Re: **PLANNING APPLICATION No: LU/79/22/PL**

COMMENTS on PLANNING STATEMENT relating to The Old Printworks, 7
Arundel Road, Littlehampton, BN17 7BY

SUBMITTED BY: Frances Aitken, The Georgian House, Arundel Road,
Littlehampton. BN17 7BY

PROPOSED ROOF TERRACE COMPUTER GENERATED VISUALS FOR REFERENCE

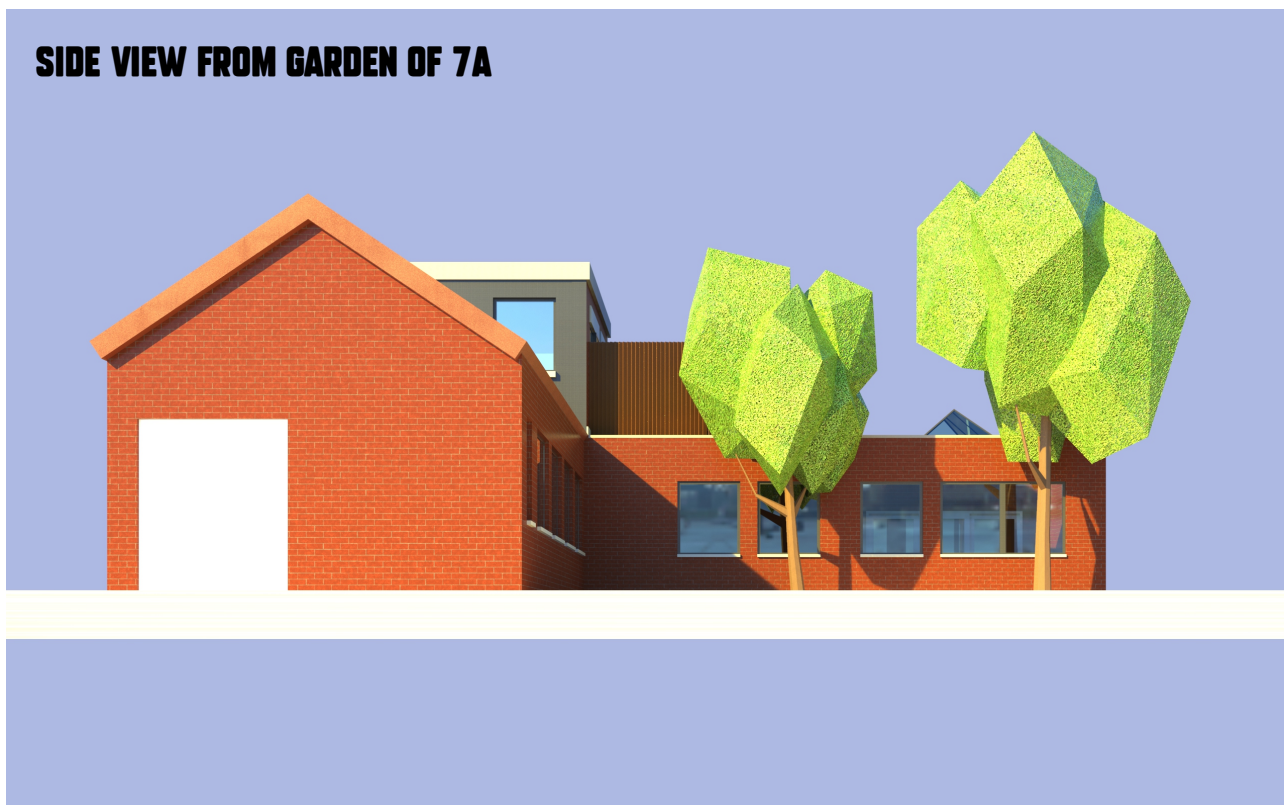
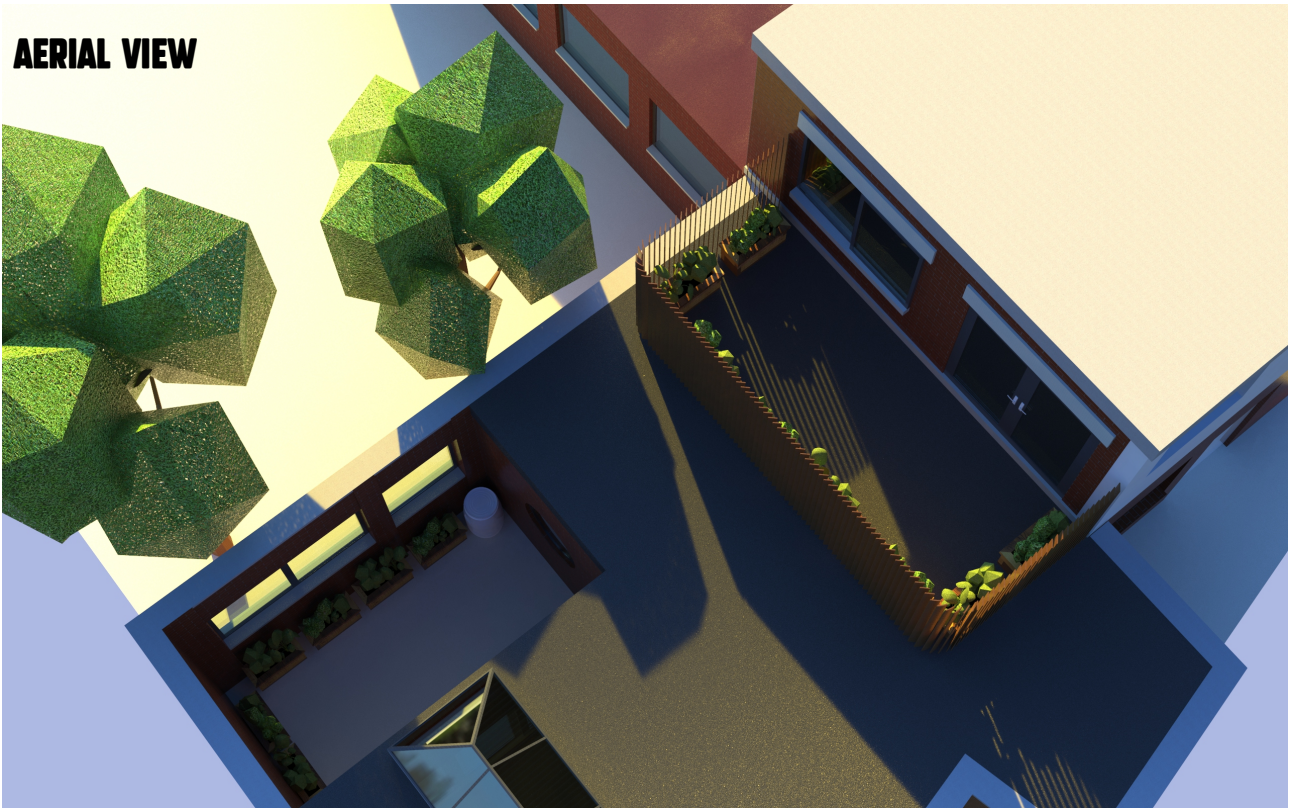
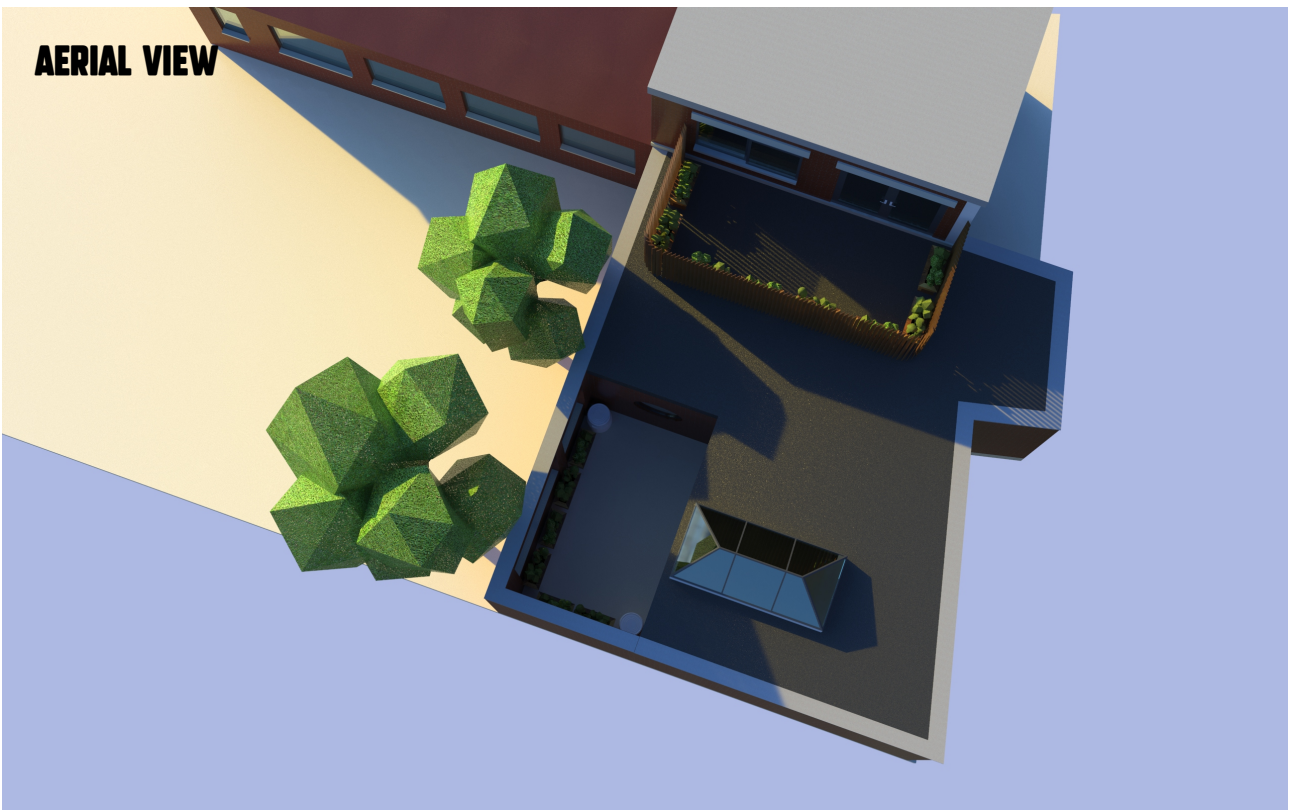
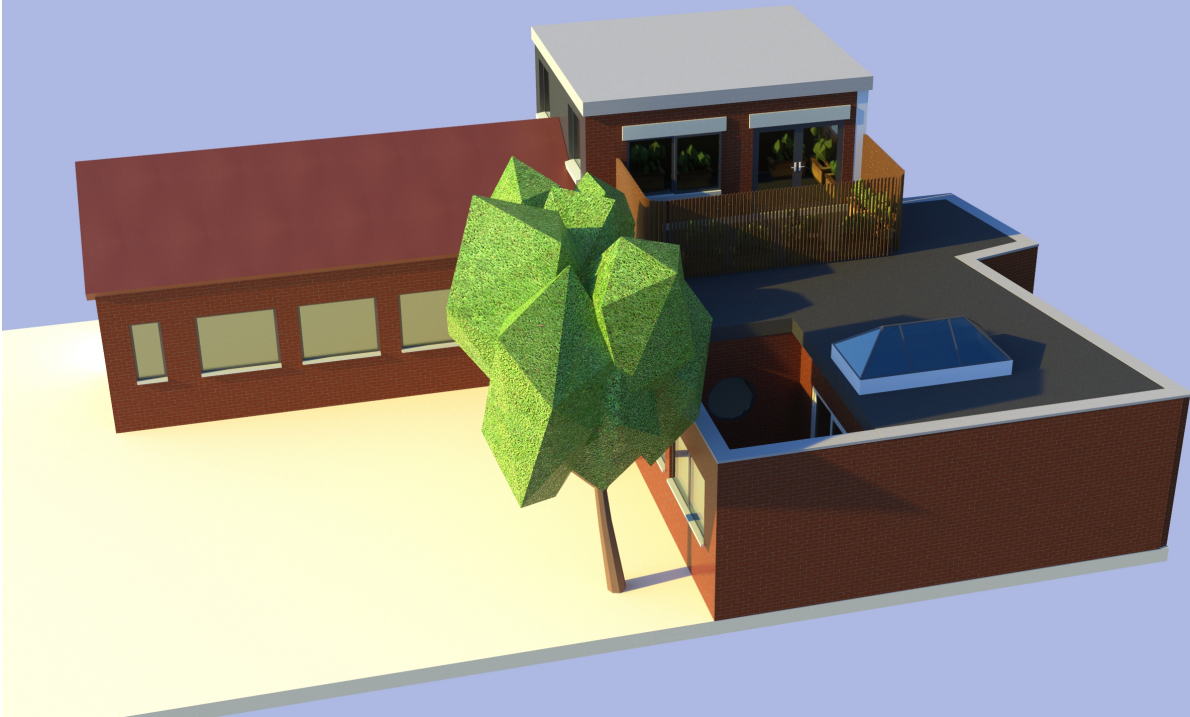
3. I have no objection to the creation of a balcony on the flat roof so long as it is screened visually from our garden by the proposed 1.7 metre high fence as set out in paras 5.21 and 5.23.
